Subject: Floodplain and Property on Alvarado and Eastern (near San Mateo and Gibson

PRIVATE DRAINAGE FACILITIES WITHIN PUBLIC RIGHT-OF-WAY DRAINAGE FILE NUMBER (L18-D63). PALOMAS SATELITE PARKING, LOVELACE MEDICAL CENTER.

5401 Easter Avenue S.E. [L18/D063], Architect Stamp dated 9/21/2001.

RE: LOVELACE MEDICAL CENTER - PALOMAS SATELLITE PAR (L18-D63).
GRADING AND DRAINAGE PLAN FOR GRADING AND PAVING PERMIT APPROVALS. ENGINEER'S STAMP DATED AUGUST 1, 2001.

SITE GRADING PLAN

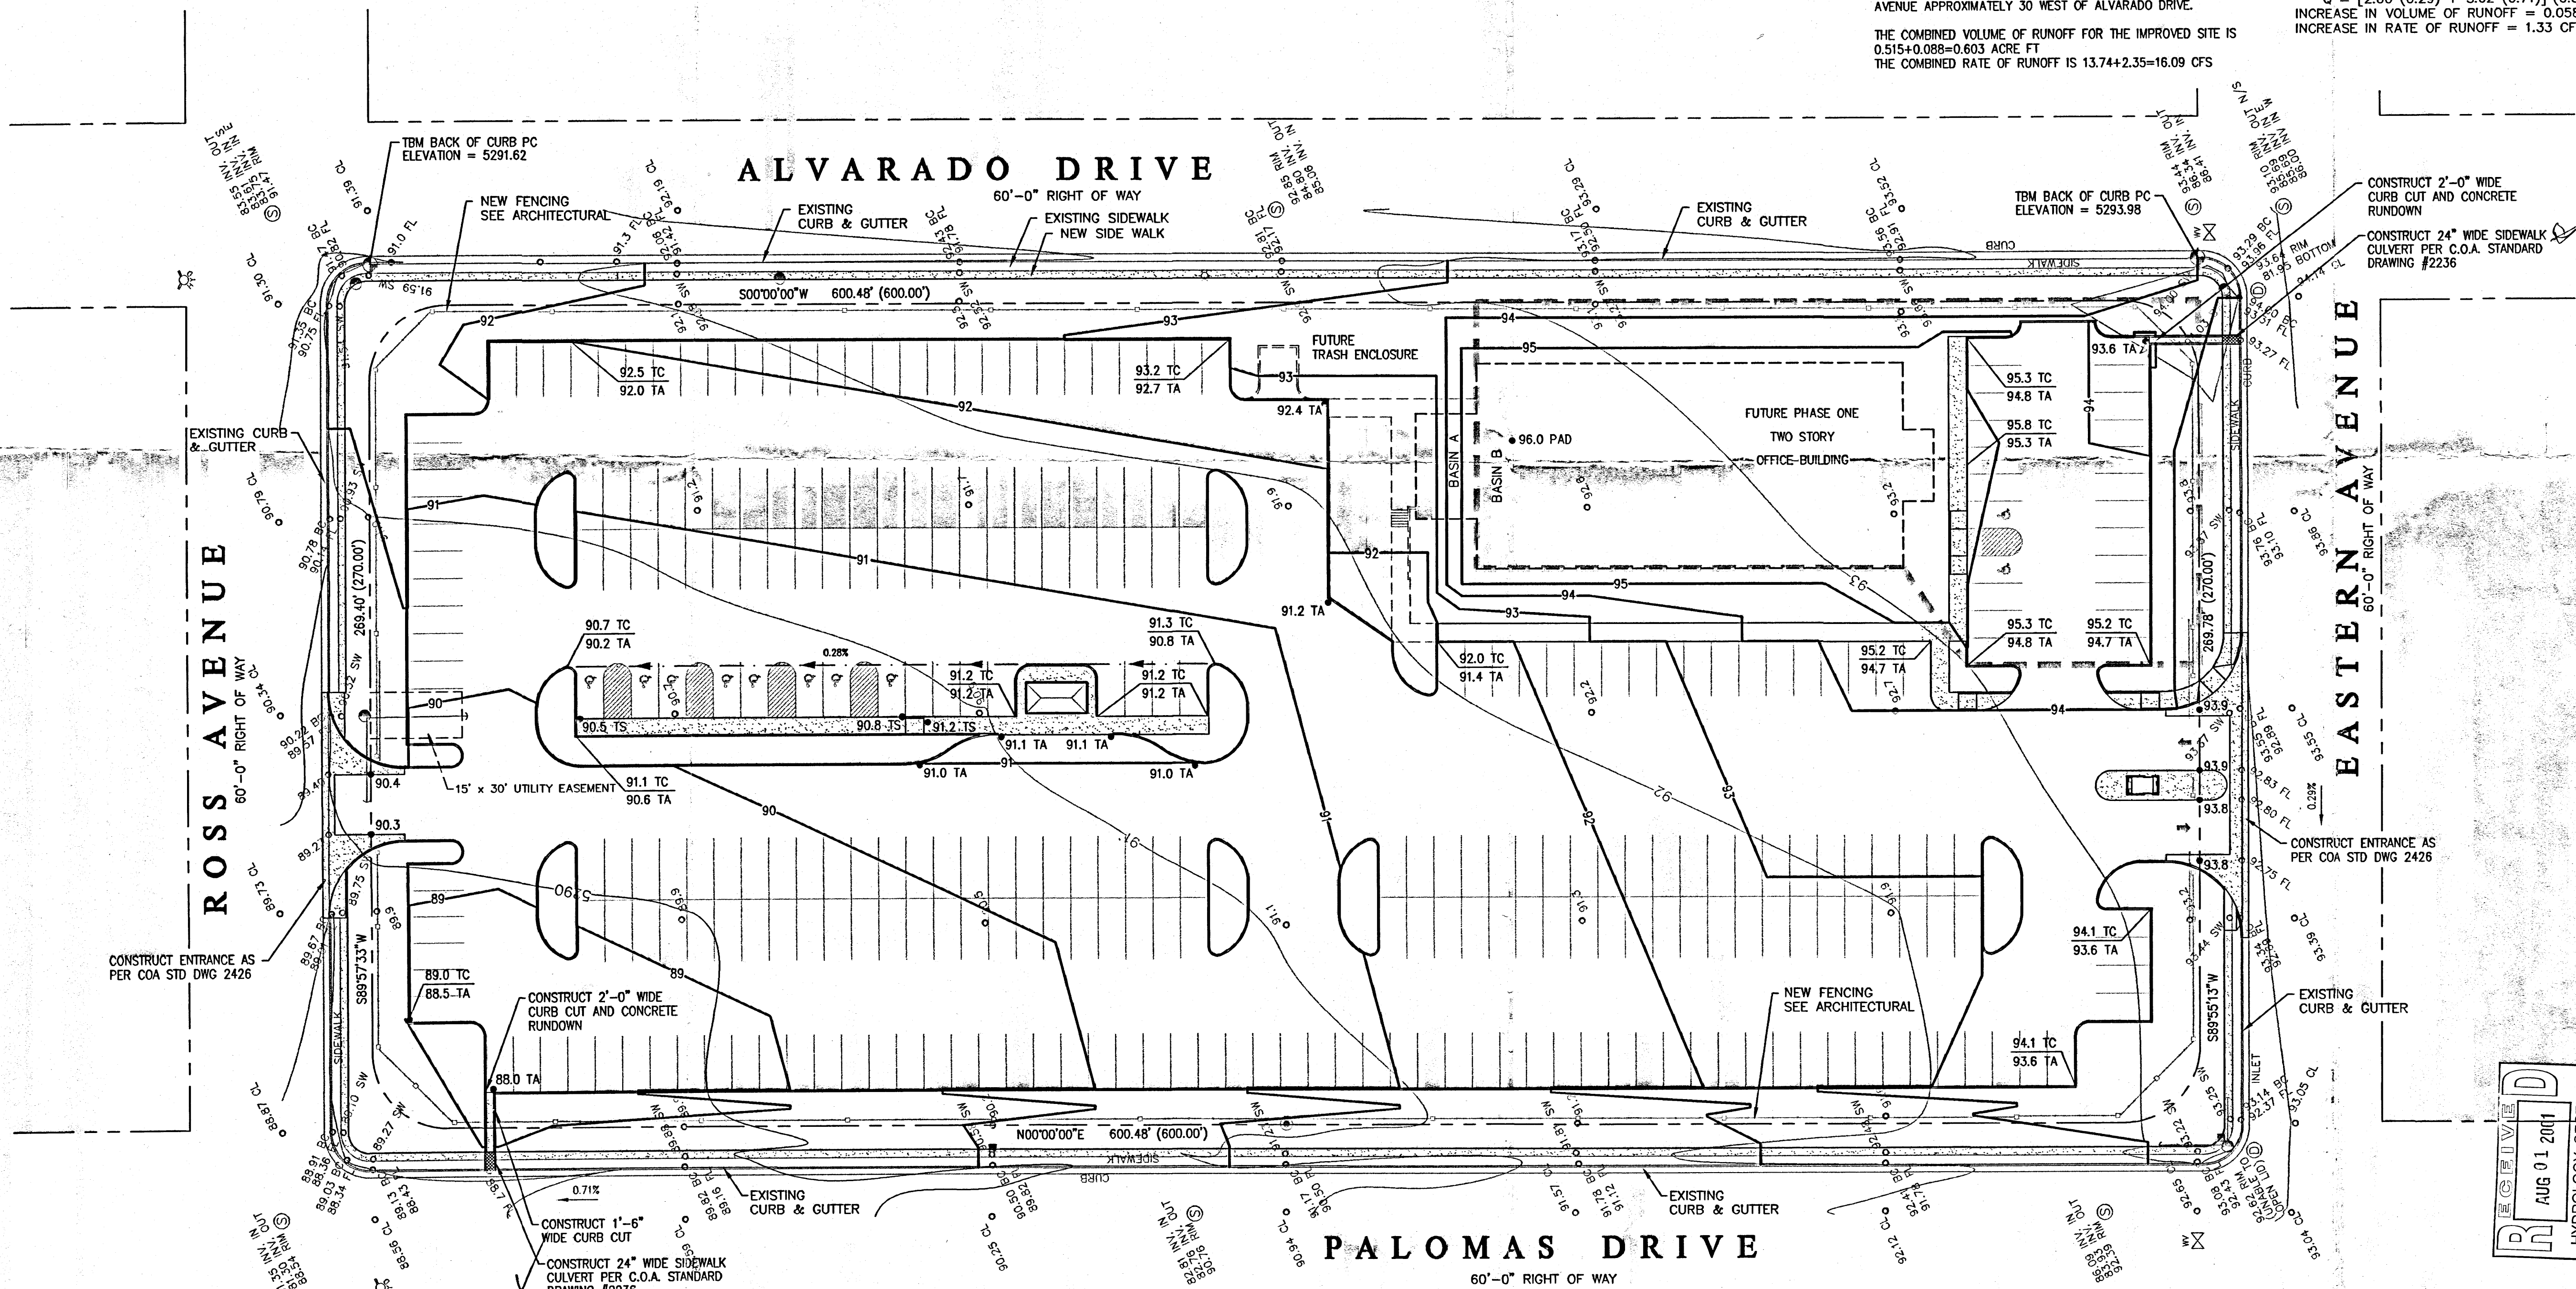
- It lies in SFHA AO (floodzone AO) with a water depth of 1 ft.
- Per COA ordinance the lowest floor elevation of each building needs to be 2 ft above the Highest Adjacent Grade for that building (or 1 ft above the water depth). This means that at least 2' of fill will be required for each building pad.

- There are 2 options for building in a floodzone:
 - 1. Submit a LOMR (Letter of Map Revision) to FEMA showing that with the past improvements (ie. Stormdrain in Gibson) have changed the limits of the floodplain. This would require a study of the larger area up to Kirkland, and submitting a CLOMR to FEMA before the LOMR. A CLOMR (Conditional letter of map revision) is in affect a pre-application to FEMA to determine major obstacles to the LOMR.

- 2. Submit a LOMR-F (Letter of Map Revision based on Fill) to FEMA showing that the building has been elevated by fill and removed from the floodplain. This would require submitting a CLOMR-F to FEMA before the LOMR-F to determine major obstacles. CLOMR-F's are not always required, but in this case because of the amount of fill and the flood-zone necking down at the NW corner, it would be too risky to proceed without a CLOMR-F

- FEMA may require that there be *Compensatory Volume* or *Equivalent Flow Area* be provided. Compensatory volume is the volume of water displaced by the buildings. For example, a park or depressed area could be located between buildings to collect the volume of stormwater displaced. Equivalent flow area is the cross-sectional area of water that flows thru the site. This area may need to be maintained, depending on what FEMA requires. Note the neckdown of the flood-zone at the NW corner. Filling in this site may cause that neckdown to widen and change the flood-zone, thus possibly requiring a LOMR from FEMA. This is another reason a CLOMR or CLOMR-F would be required.
